Please take this as the LLFA's updated formal response to AB/88/19/PL.

Based upon the current proposals, our objection still stands. To try and overcome this objection, the applicant might like to take account of the following observations/suggestions;

SITE DRAINAGE PLAN
SCALE 1:200

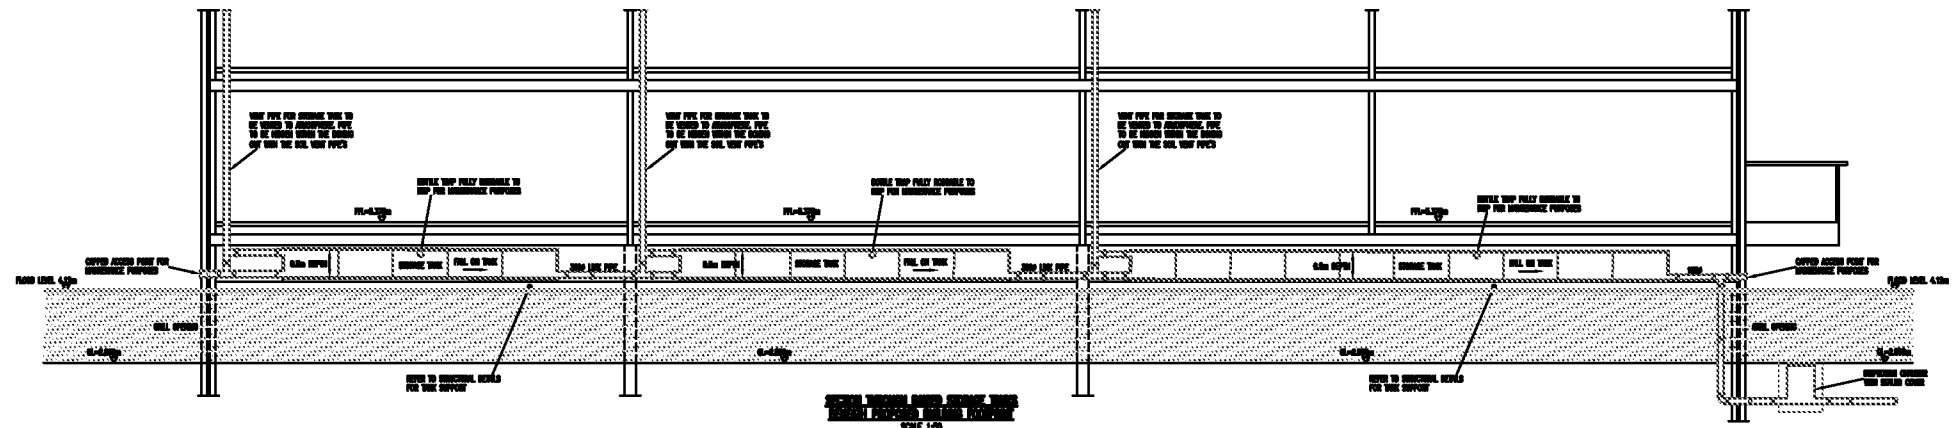
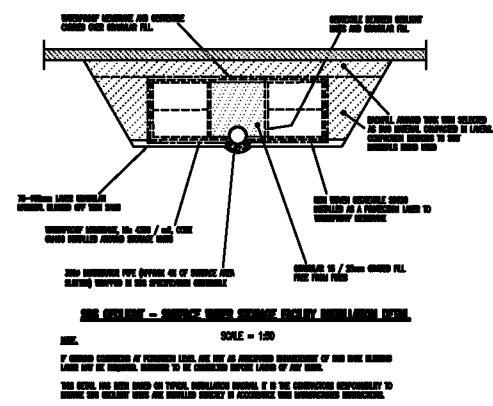
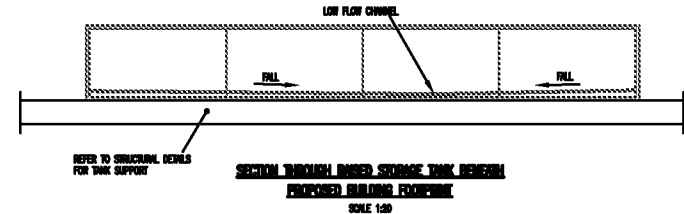
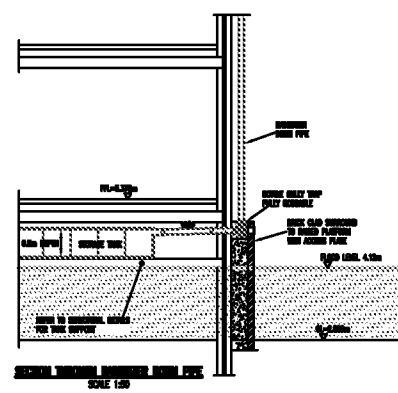
1. Fluvial flood water (designing against the 1 in 100 yr +105% modelled event) will still overwhelm the car park drainage and parts of the roof drainage system (The roof water currently discharges into the system serving the permeable surfaced car park). Consider separating the roof water from the system serving the permeable pavement. I.e. provide at least two separate outfalls (possibly three bearing in mind item 2 below) to the watercourse/s with independent hydrobrakes and flap valves. Sealing all components of the roof water system below 4.12m AOD to prevent fluvial flood water inundation i.e. sealed manhole covers, etc. Accept that the permeable pavement system will be inundated with fluvial flood water, since there is little that can be done to prevent flood water entry. Compensate for this by overdesigning the permeable pavement storage (factor to be agreed).

2. Tank access for maintenance is still an issue. Whilst an attempt has been made to address this, the western tanks having slightly better access than the eastern tanks, however, this still falls short of what is required. Perhaps consider moving the western storage from beneath the building to the area between Ford Rd and the building, ensuring cover levels are set above 4.12m AOD and sealed for good measure? Can this option be achieved? Connect this system independently to the northern watercourse.

3. Suitable access to the eastern tanks –including the orifice control is a challenge. Full safe access is required to all tank sections/link pipes, etc for inspection/cleaning. The fact that access points will be at a height of around 1.5m above ground level is also a key point here and a safe form of access will need to be provided. Whilst a low flow channel and rodding points will provide some help, it is not considered a total solution and needs further investigation to see what is possible. This is where the building would benefit from a blue roof arrangement as an alternative arrangement.....

4. Orifices to be protected by perforated filters to reduce risk of blockage.
5. All RWP's to connect to tanks at soffit to soffit level and somehow incorporate silt traps (roofs still produce siltation due to leaf fall collected in gutters/moss growing on the roof, etc). Provide a safe means of access to rodding eyes/silt traps.

6. Both systems to store 1 in 100 year event + 40% (without flooding) and designed against a surcharged outfall i.e. assume ditch is full to top of bank. Also simulate discharge (roof water systems) against predicted flood level of 4.12m AOD.

7. Details of low flow channel for tanks/gradient/tank material/link pipes to be min 300mm diameter.
